September 16, 1996

RE: ROCKY MOUNTAIN R.V. (L22-D35) DRAINAGE REPORT SUBMITTAL FOR SITE DEVELOPMENT PLAN FOR SUBDIVISION APPROVAL, BUILDING PERMIT APPROVAL, AND GRADING PERMIT APPROVAL. ENGINEER'S STAMP DATED 9-13-96.

Based on the information provided on your August 20, 1996 submittal, the above referenced project is approved for Site Development Plan for Building Permit approval. Prior to Building or SO #19 Permit approvals, please address the following comments:

ENGINEER'S SEAL ROCKY MOUNTAIN RV-MARINE FACILITY GRADING AND DRAINAGE PLAN 12,700 CENTRAL S.E. ALBUQUERQUE, NM 87123	DRAWN BY: Pvg DATE: 6-22-94 9412GR.DWG SHEET #
	TERRA WEST DEVELOPMENT MANAGEMENT SERVICES 4421 McLEOD ROAD, NE SUITE D ALBUQUERQUE, NEW MEXICO 87109 (505)883-7592	JOB # 940012

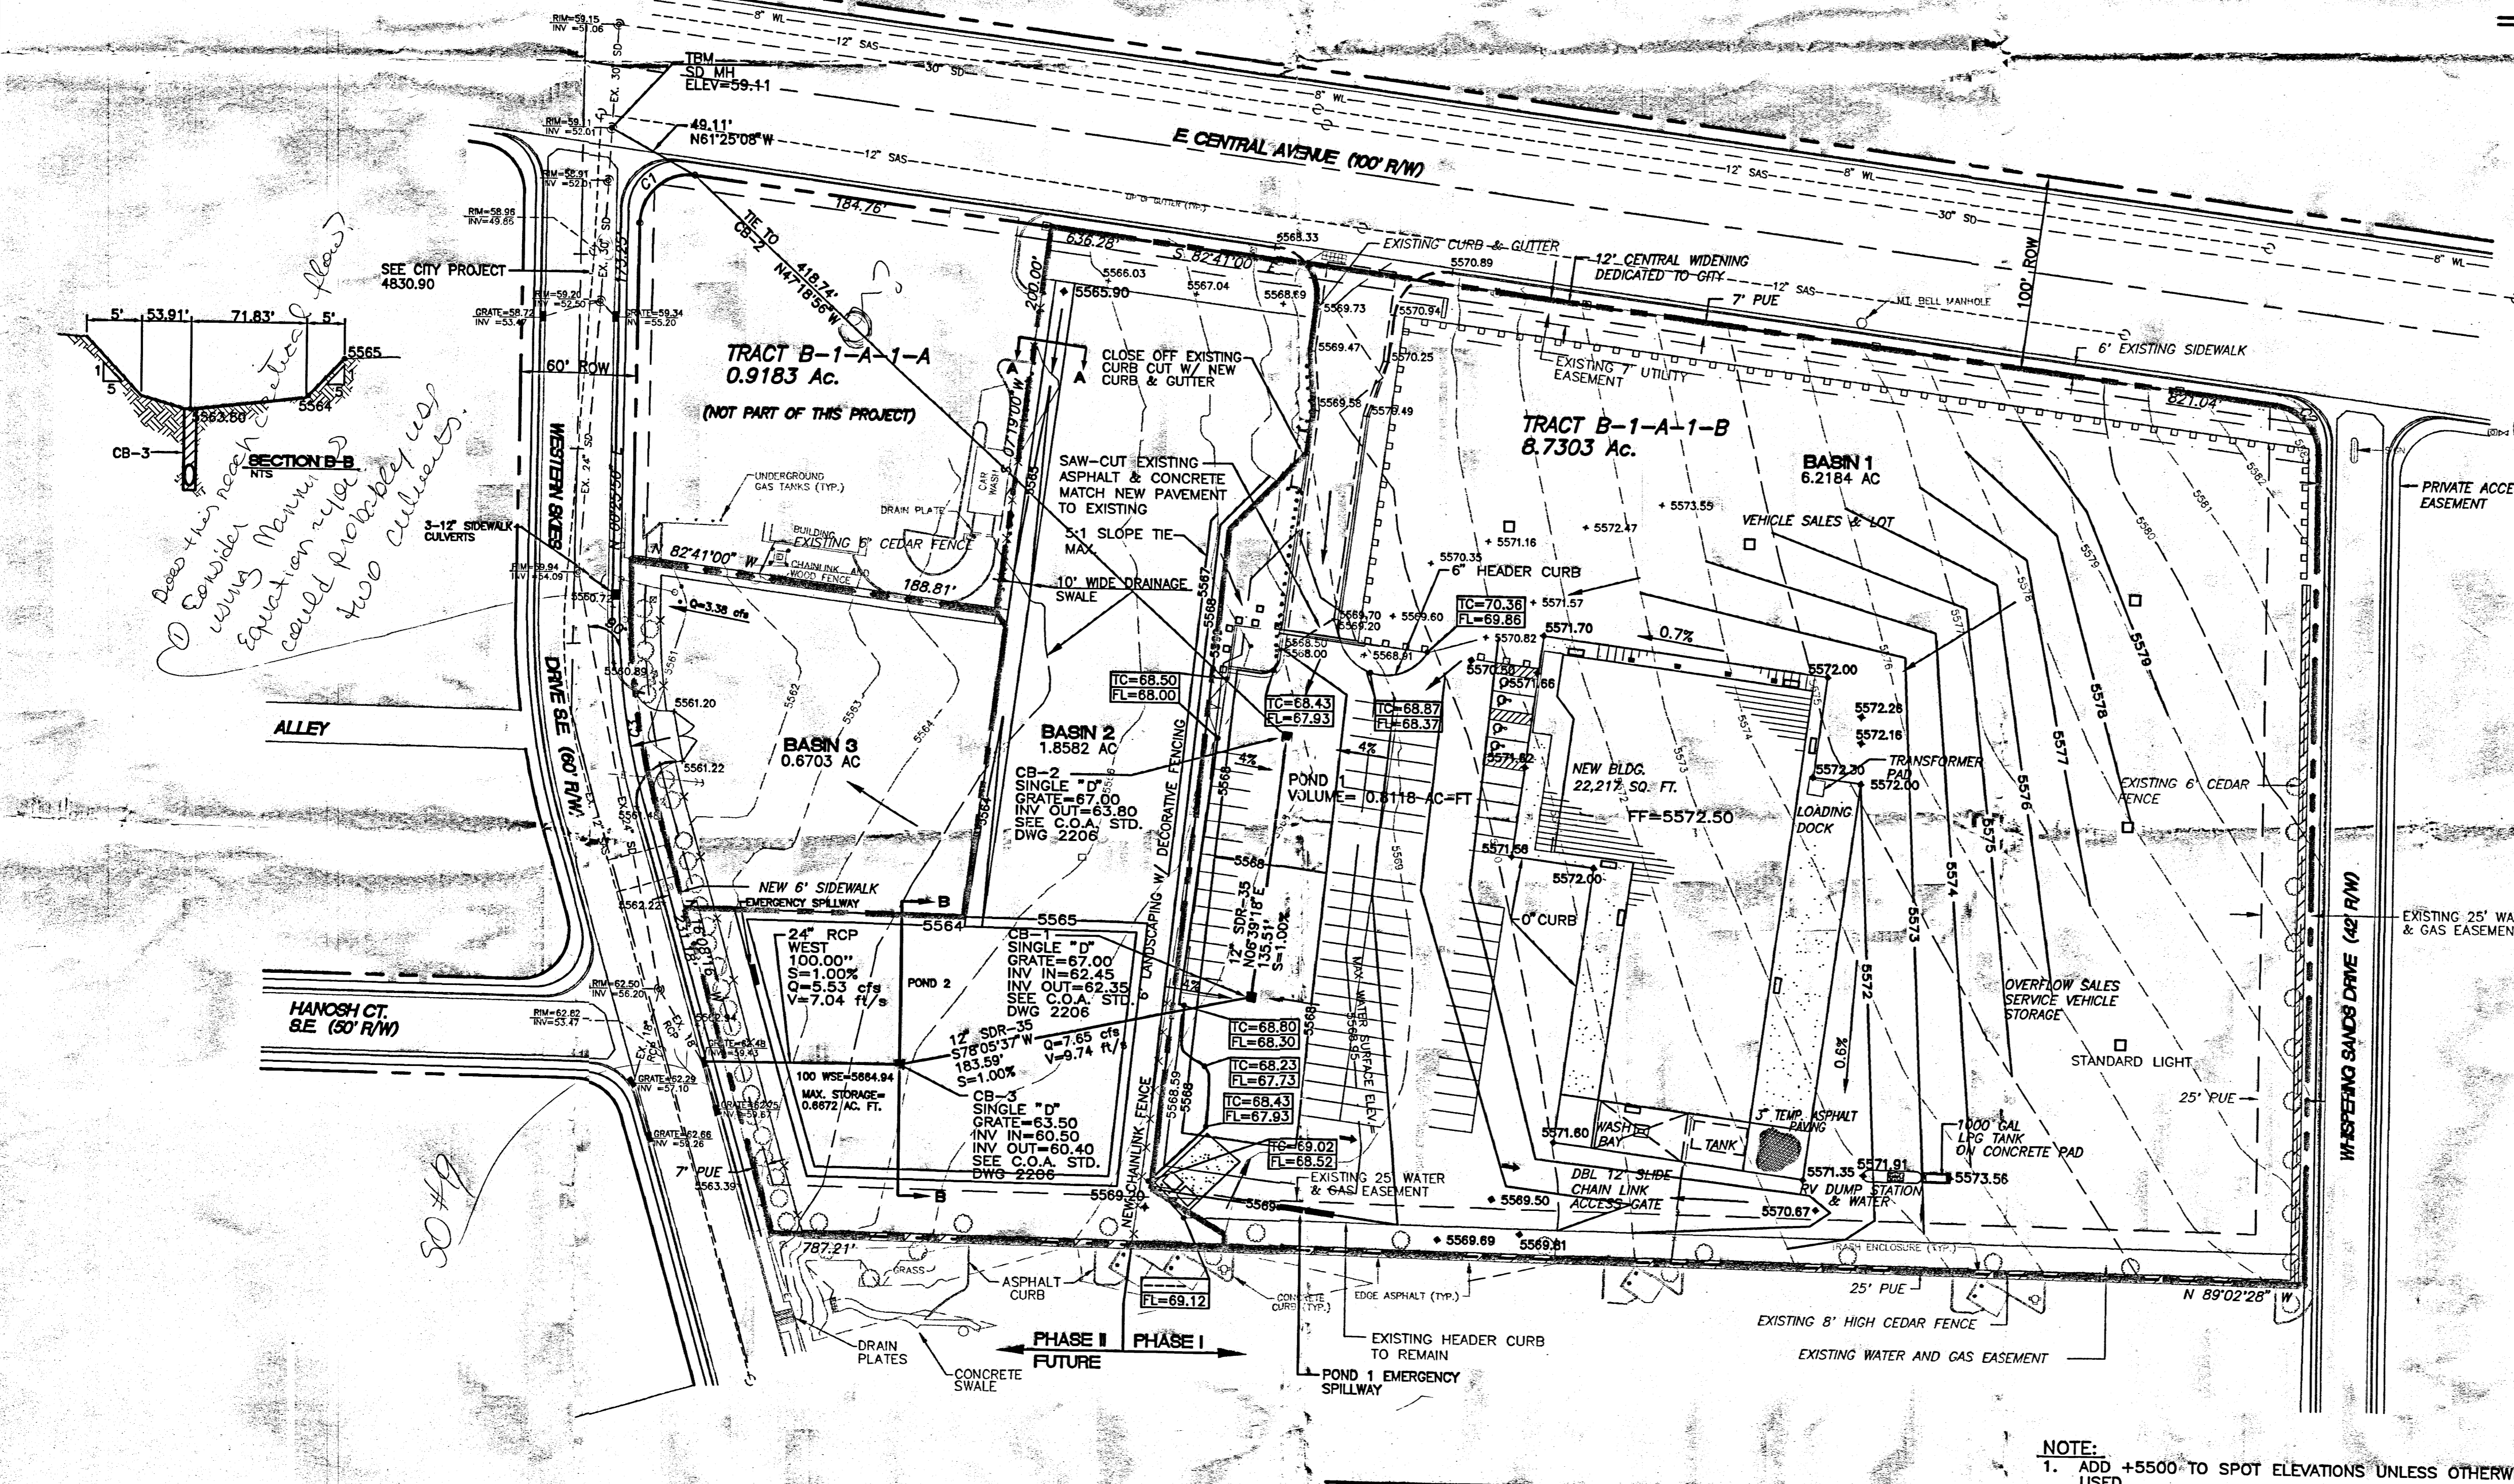
1. An SO #19 Permit is required for this project due to the work proposed in the right-of-way. Please be certain to show the required notes and sign-off block on the plan sheet. Also, provide two copies of the Grading and Drainage plan.
2. Shown on your plan sheet is a distance and bearing line from catch basin 2 to the corner of Western Skies and Central. Please change the line type. It looks very similar to a storm drain line.
3. If you desire, you can use an 12-inch pipe with a 10-inch orifice to tie into the back of the existing inlet on Western Skies.
4. Are your sidewalk culverts in a submerged condition? If not, I believe you can get away with using two sidewalk culverts instead of three
